Harnett County Government Complex  
307 Cornelius Harnett Boulevard  
Lillington, NC 27546

September 26, 2005

**Re: Status of Improvement Permit Application #05-5-12660RR  
Letter #4**

Revised
SITE PLAN APPROVAL
DISTRICT BOARD USE SFD
7/12/15
ZONING ADMINISTRATOR
PR

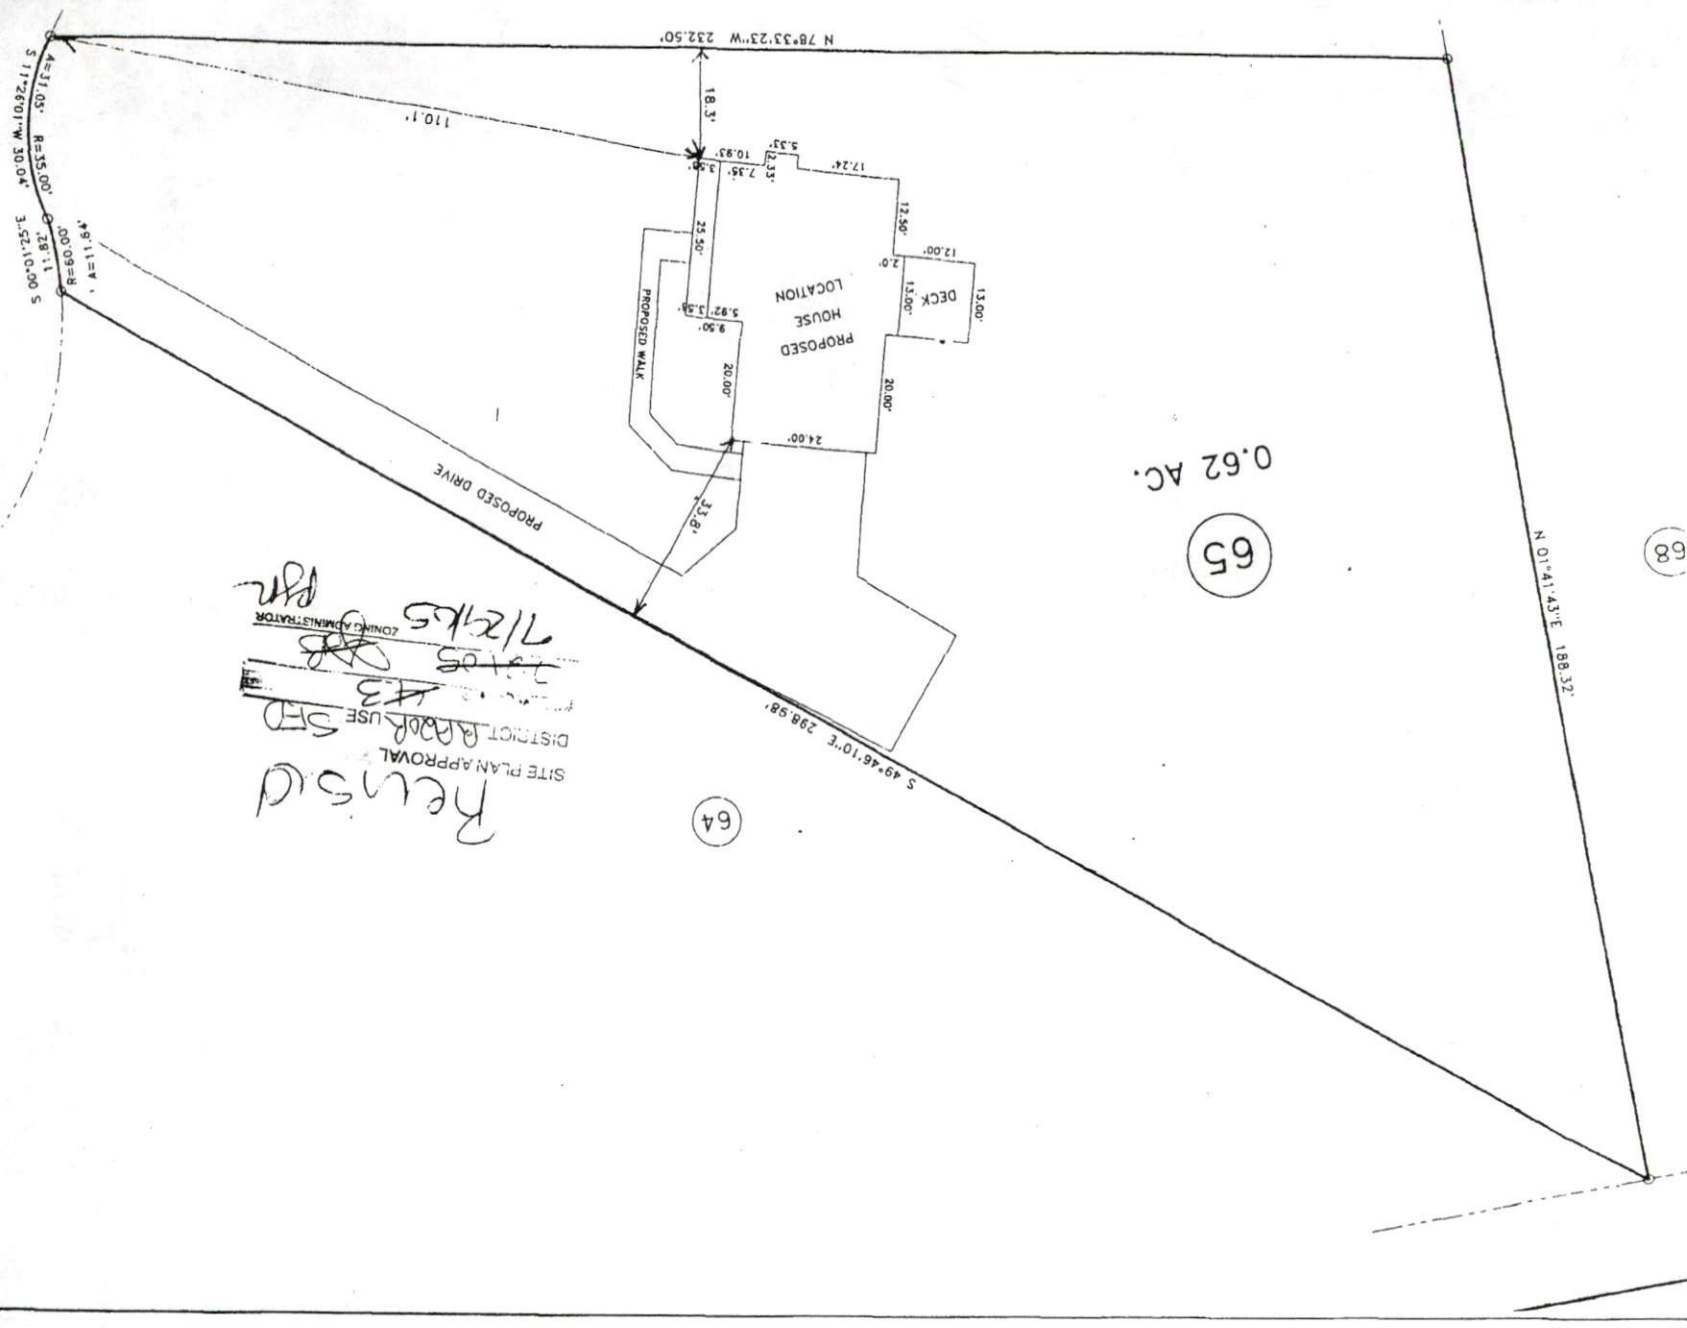
- 1. Property lines/corners not marked or labeled
- 2. House corners not marked or labeled
- 3. Directions not clear to property
- 4. Property needs brush or vegetation removed
- 5. Backhoe pits required
- 6. Other **Move house to set backs shown.**
